From: Charles Fox [REDACTED]
Sent: 15 September 2013 13:51
To: Planning
Subject: OBJECTION TO NEW BUILDING PROPOSED FOR BROADMARK WAY

Re; planning lists ref:R/190/13/1 .

A planning application ref: R/190/13/1 has recently been submitted for land the rear of 20 and 22 Broadmark Lane which is accessed via Broadmark Way.

DRAWING TITLE
PROPOSED ELEVATIONS AND
STREET ELEVATION

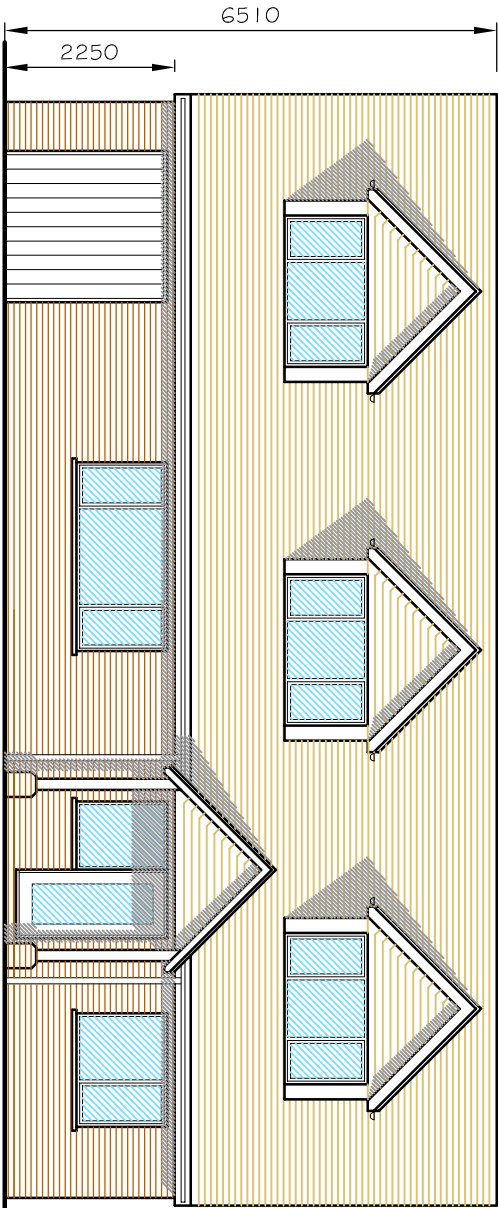
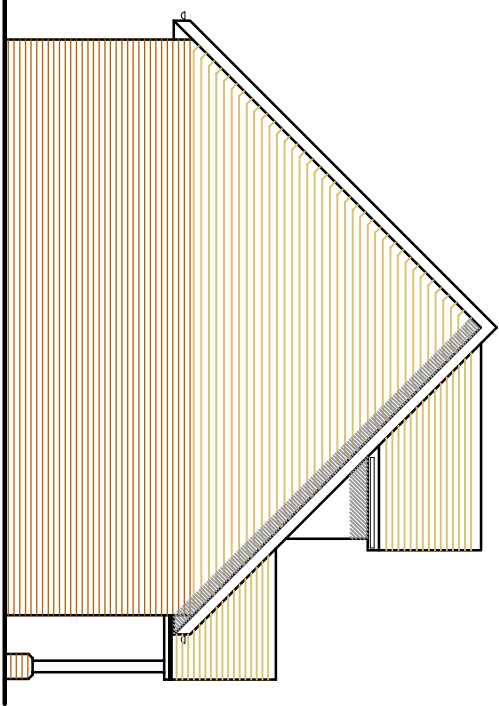
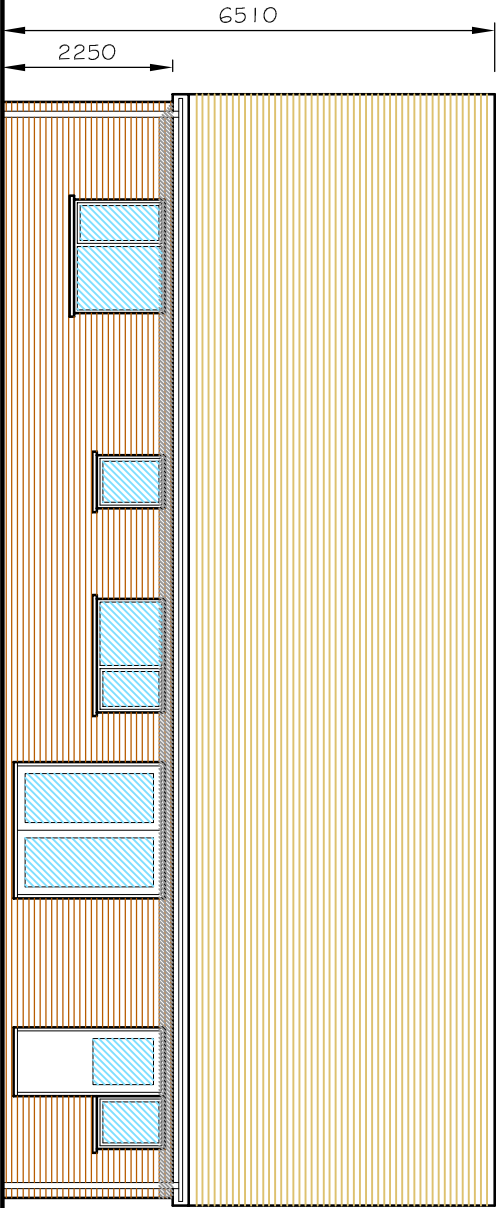
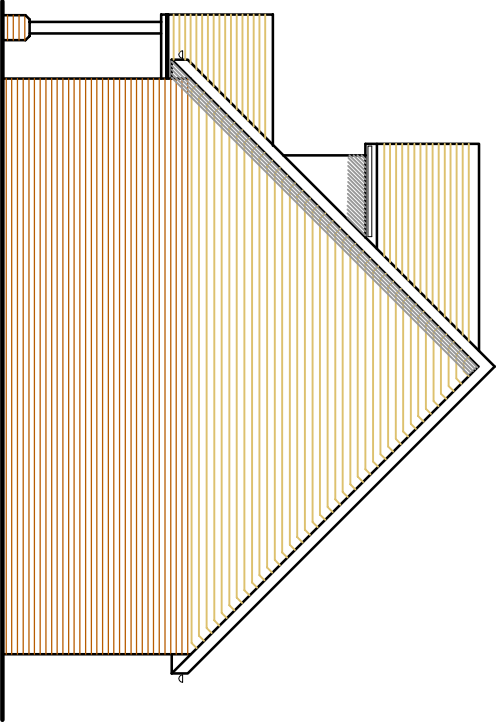
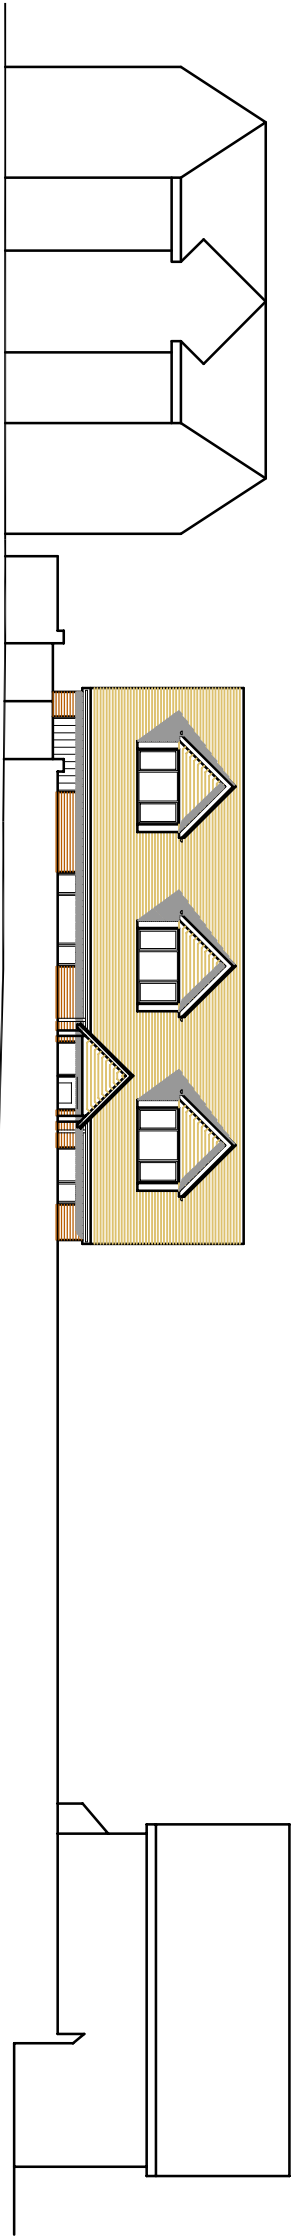
5. The proposal due to its overbearing size (height and mass) will result in
significant shadowing and loss of light to the gardens of 18, 20 ,
6. The proposal due to its overbearing size (height and mass) will result in
a significant obscurity and dramatically changed outlook to and
from 4 Broadmark Way residence.

The proposal, by reason of the height and mass, would present an over-bearing appearance, which would have a detrimental impact on the visual amenities and quiet enjoyment of the neighbouring property, namely Nos. 20 and 22 Broadmark Lane, and 4 Broadmark Way.

DRAWING TITLE
SITE LOCATION AND LAYOUT PLANS

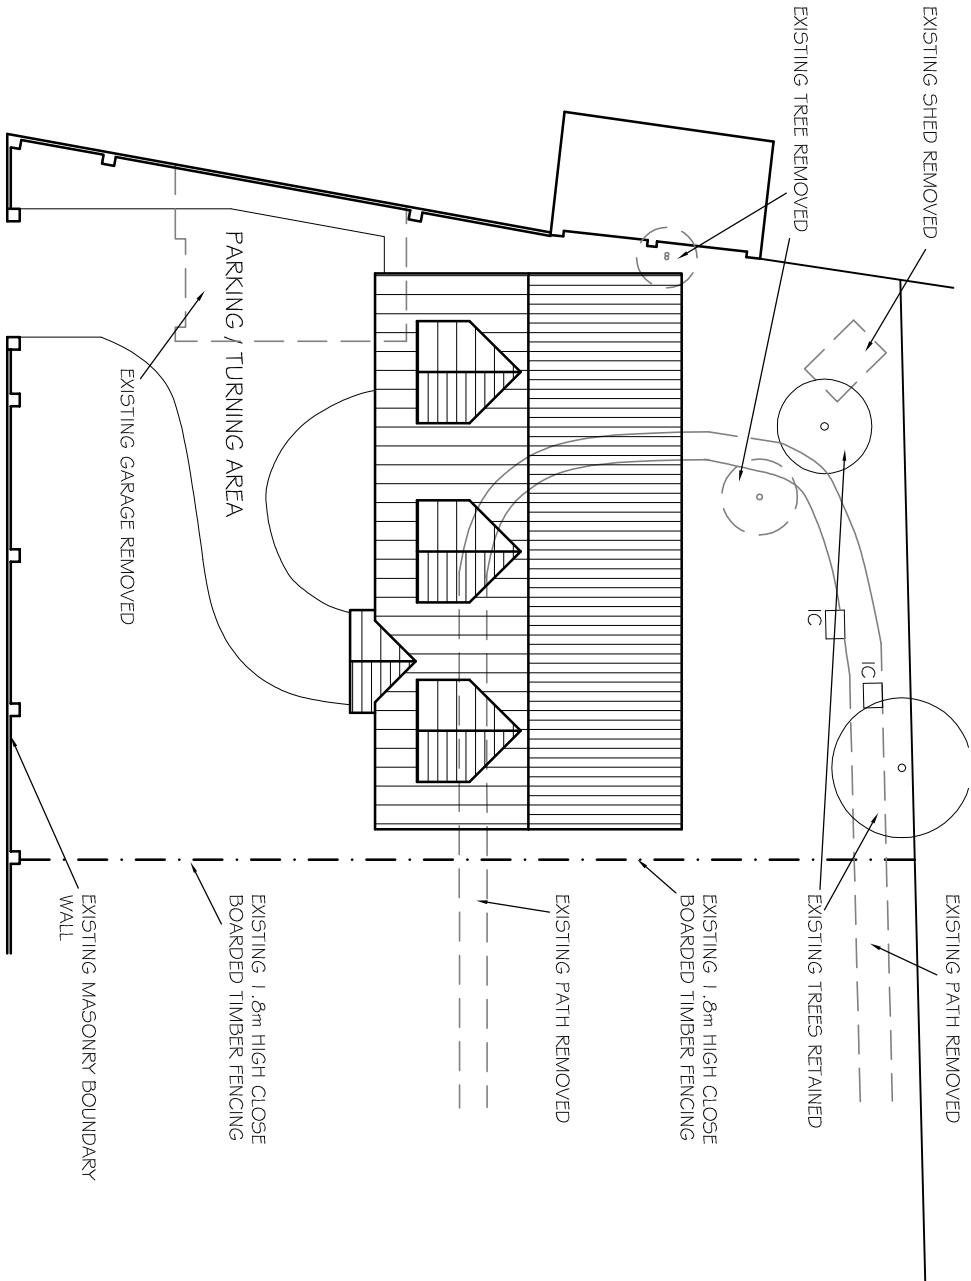
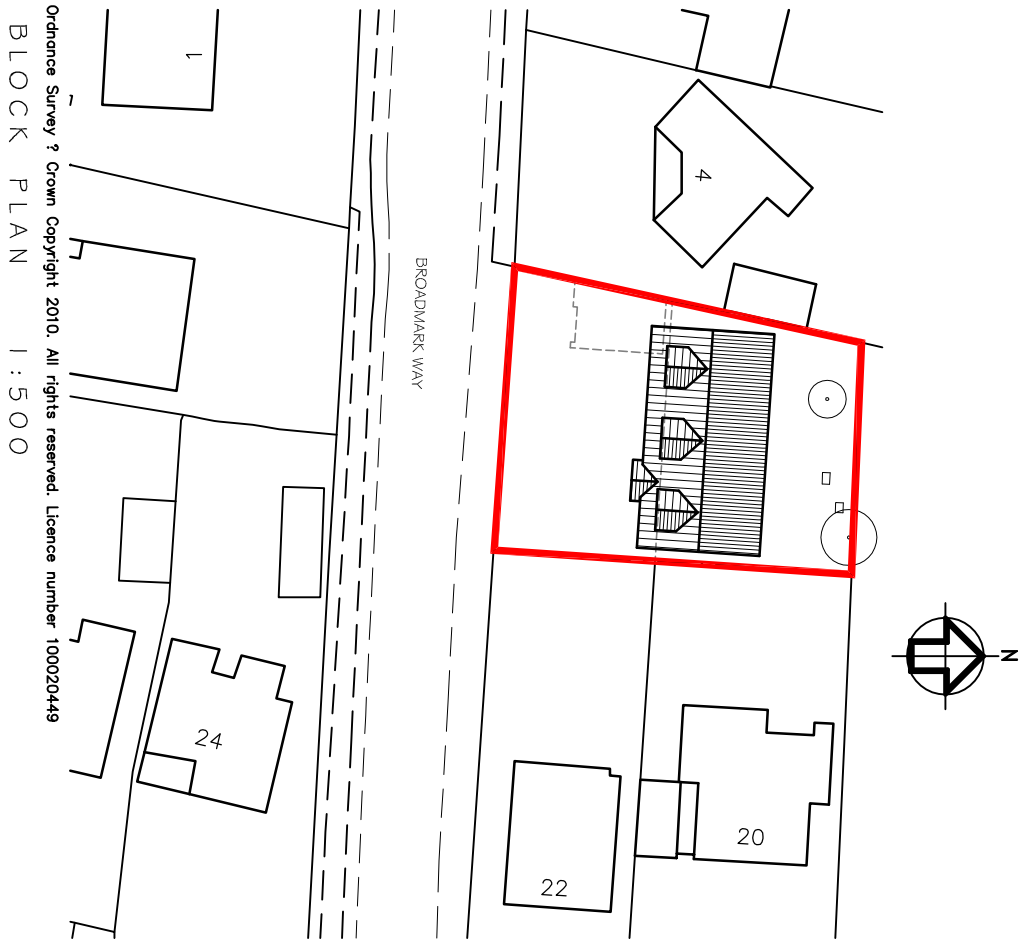
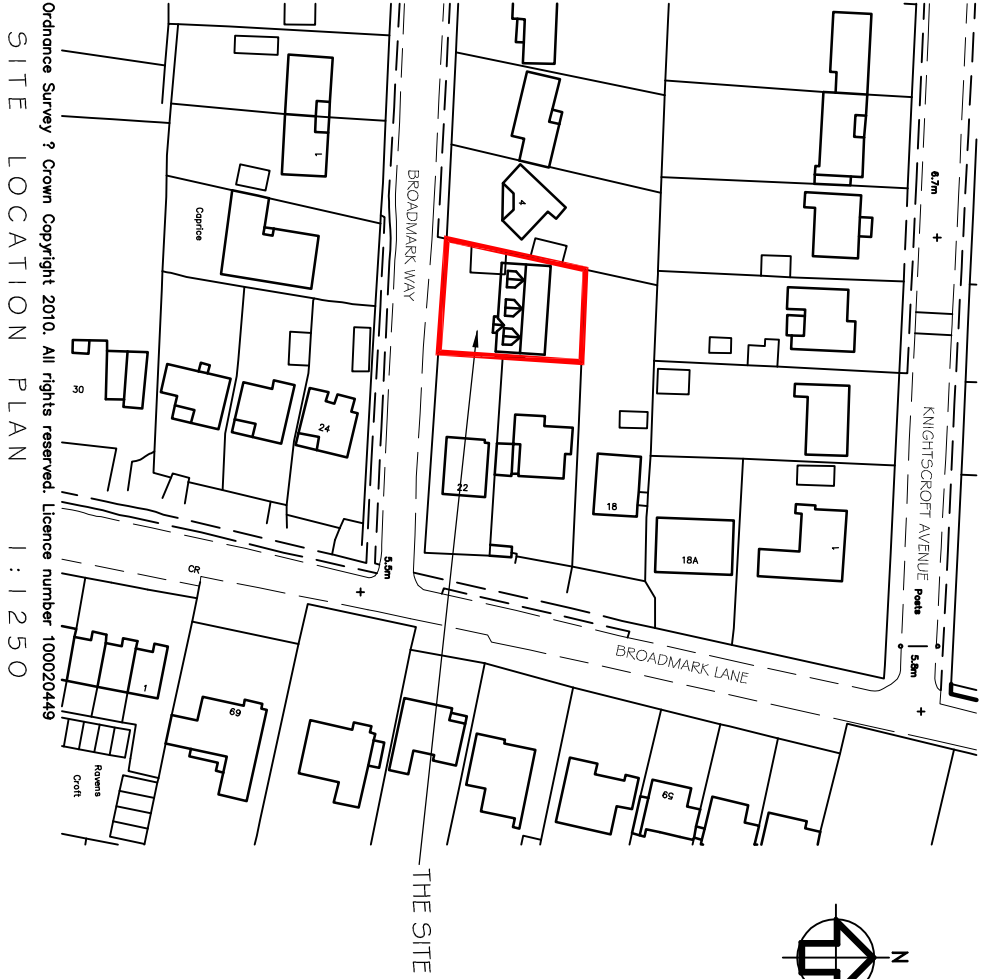
1. The house proposed in 2010 had a footprint of approximately 70 sq.ms.
The house now proposed has a footprint of approximately 112 sq.ms.
This is a 60% increase in the size of the building.

2. This new proposal is 27% closer to Broadmark Lane properties, and
46% closer to 4 Broadmark Way.
3. The house now proposed reduces the garden size of both 20 and 22
Broadmark Lane by approximately 400 sq. metres making both existing
plot sizes uncharacteristically small.

4. The proposal results in an overlooking of the private amenity space
of 22 Broadmark Lane, resulting in 22 Broadmark Lane being infringed
having a detrimental effect on quiet enjoyment time and use of amenity.

7. The proposals do not provide adequate off road parking and suitable turning space for more than one vehicle. (Planning proposals register 2 cars).
8. The new proposal is far more cramped on the site in relation to the existing properties at 4 Broadmark Way and 20 and 22 Broadmark Lane than was the 2010 scheme which was refused primarily on these grounds.
